Subject: FW: Littlehampton, Cornfield Close LU/354/19/DOC

'the number of charging points (25) in relation to the number of dwellings (77) does not appear adequate. May the applicant also please provide a scheme (to accompany the submitted plan) of electric vehicle charge points (to include information on how the plan will be implemented, details of accessibility provision(s) and the ratio between occupants/dwellings and charge points).

I understand you are the case officer for condition 15 (EV charging) for Cornfield Close, Littlehampton. We were disappointed with the refusal of this condition especially as we had no discussion with the council during the decision making process to facilitate an approval of the condition discharge. I would be grateful if you could please provide me with some further details as to why this condition was refused so we can progress with a resubmission.

REV	DATE	NOTE
DEVELOPMENT		
CORNFIELD CLOSE LITTLEHAMPTON		
DRAWING TITLE		
PARKING PLAN

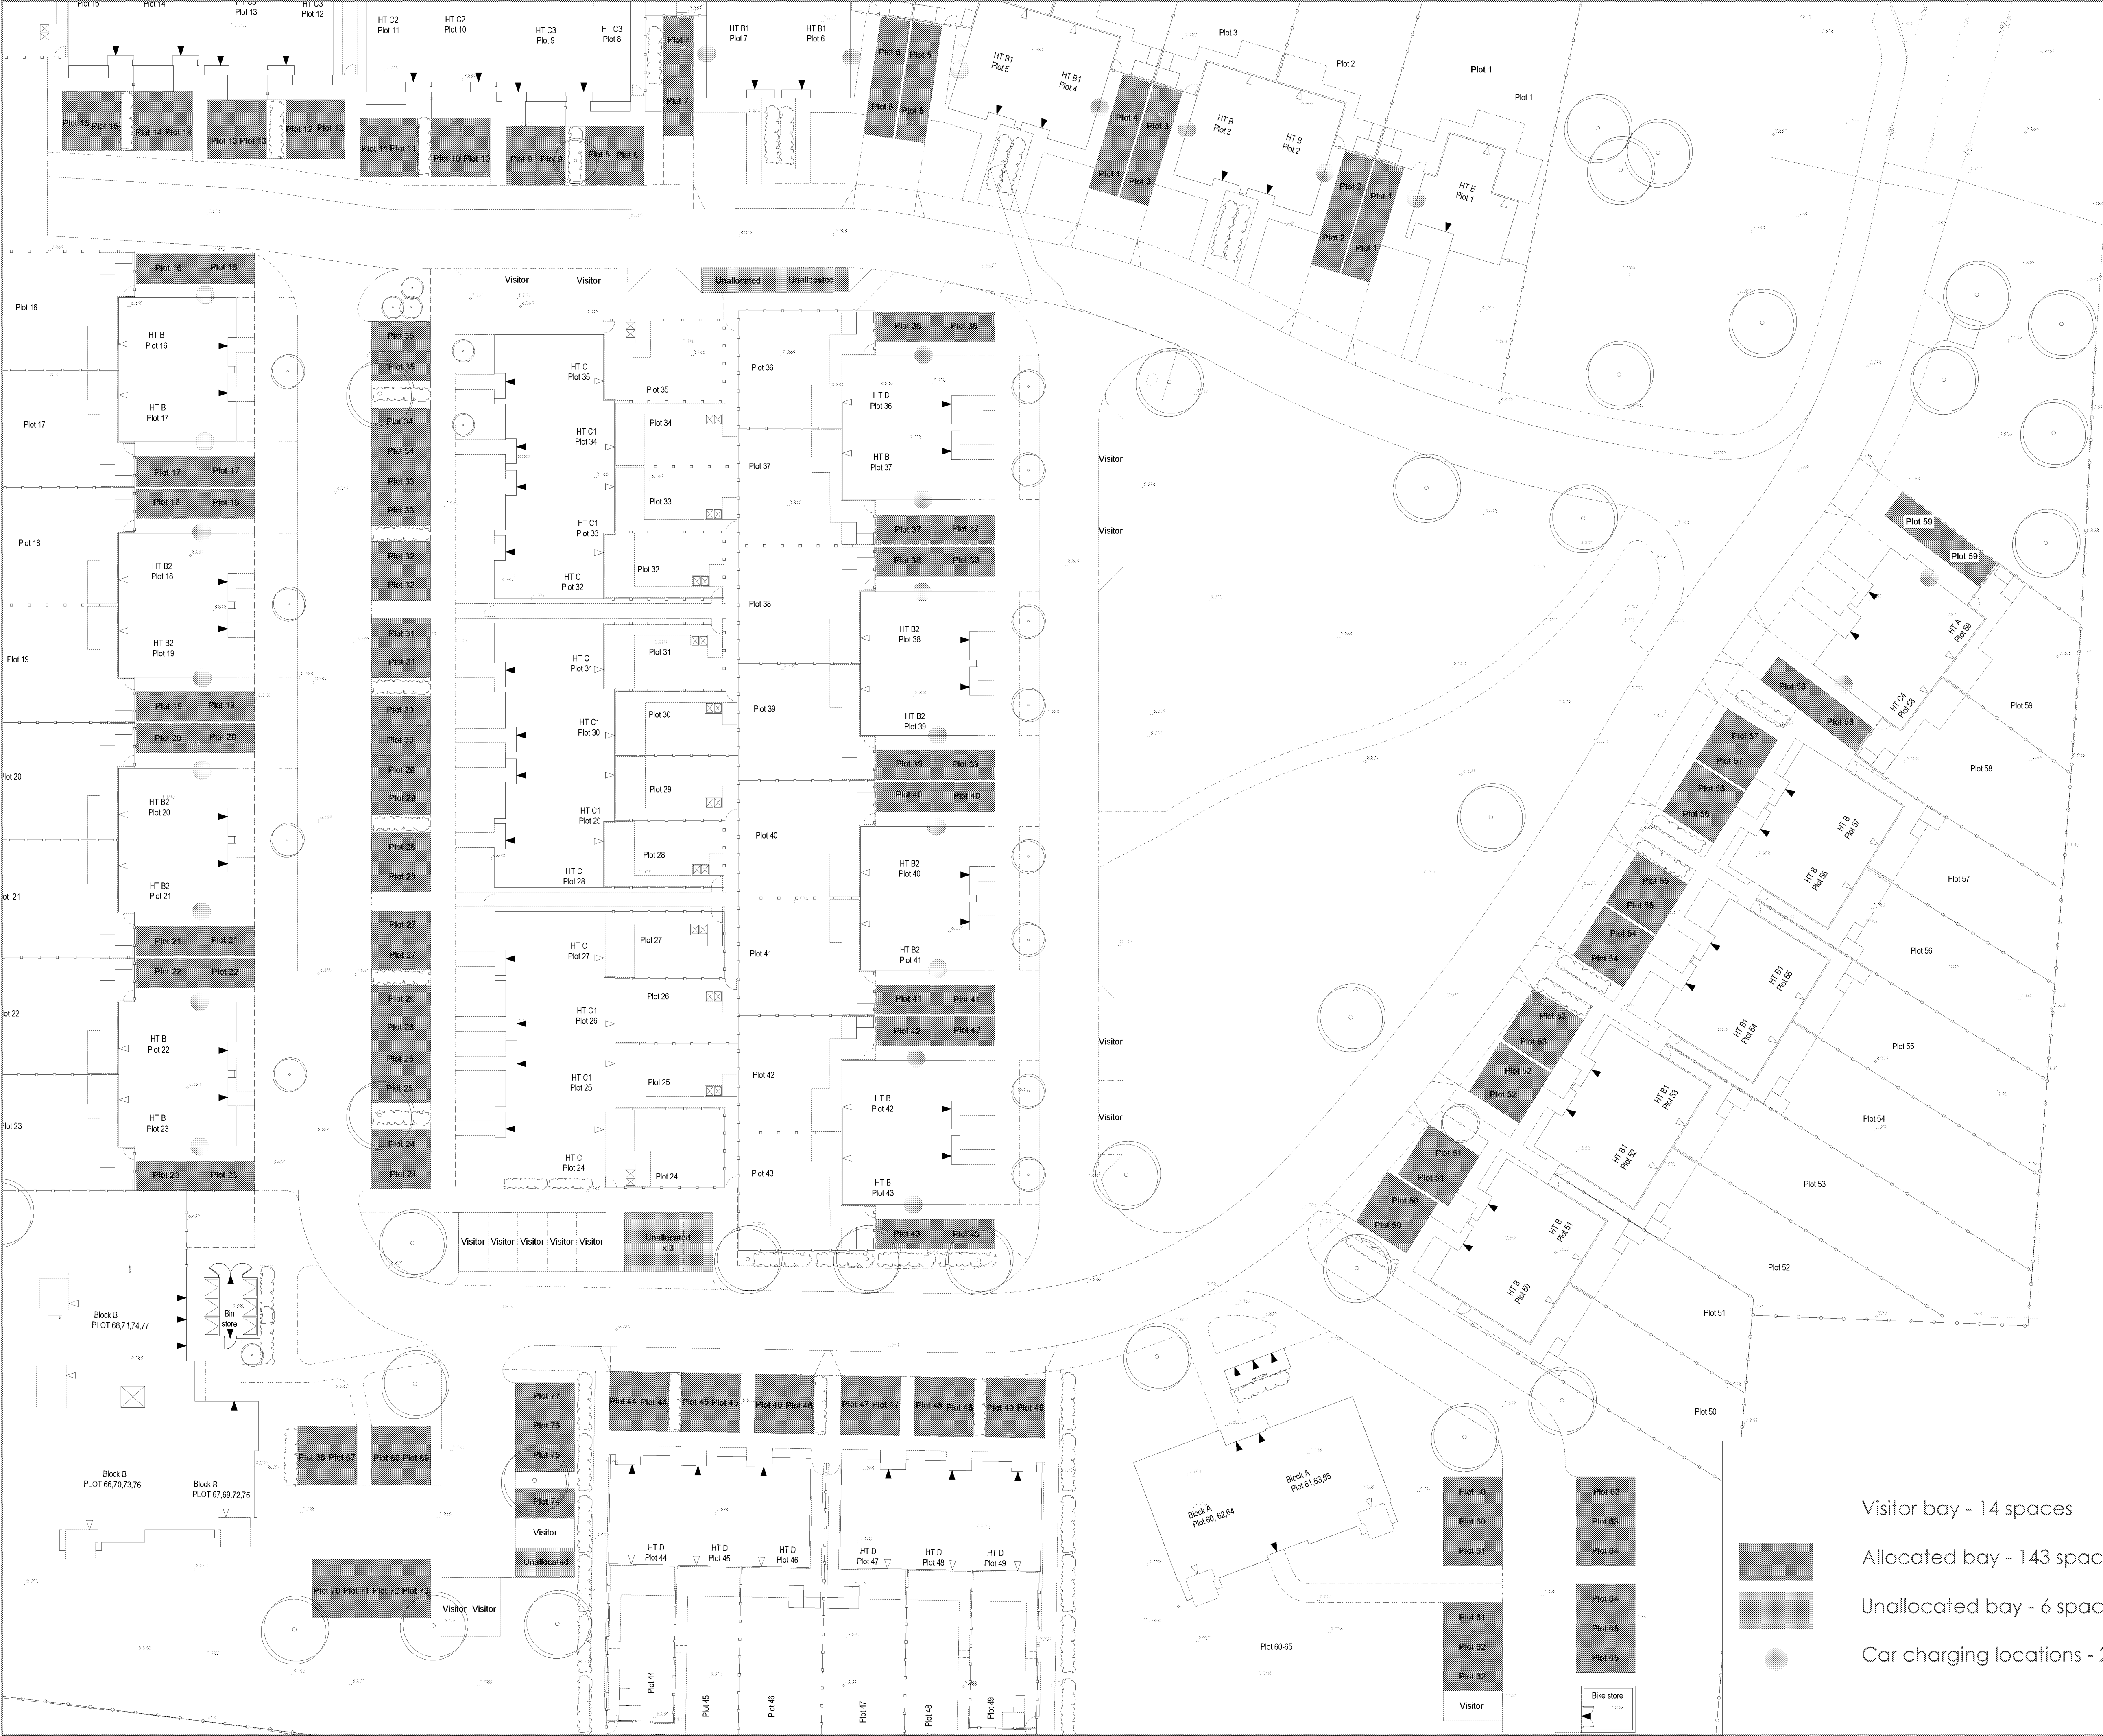
It is my understanding of the ADC Parking Standards Supplementary Planning Document that 100% of houses with garages or driveways shall have an electric vehicle charging point and that a certain percentage of *other* parking spaces should have active charge points. I think perhaps the developer has looked at the percentage of all the properties as opposed to the percentage of dwellings which do not have driveways or garages. From the submitted plans, it appears that a number of properties (specifically 8-15, 24-35, 44-49 and 50-57) have allocated private parking associated with their plot (in the form of a driveway) but no access to a charge point. It seems that future residents of the flats will not have any access to charging points.

To clarify EH's position, it is anticipated that every property with a garage or driveway to have their own electric vehicle charging point unless there is a justifiable reason as to why it is not possible. Furthermore, residents of flats and/or apartments should have access to a shared charging point, as per the percentage stated in the aforementioned document.
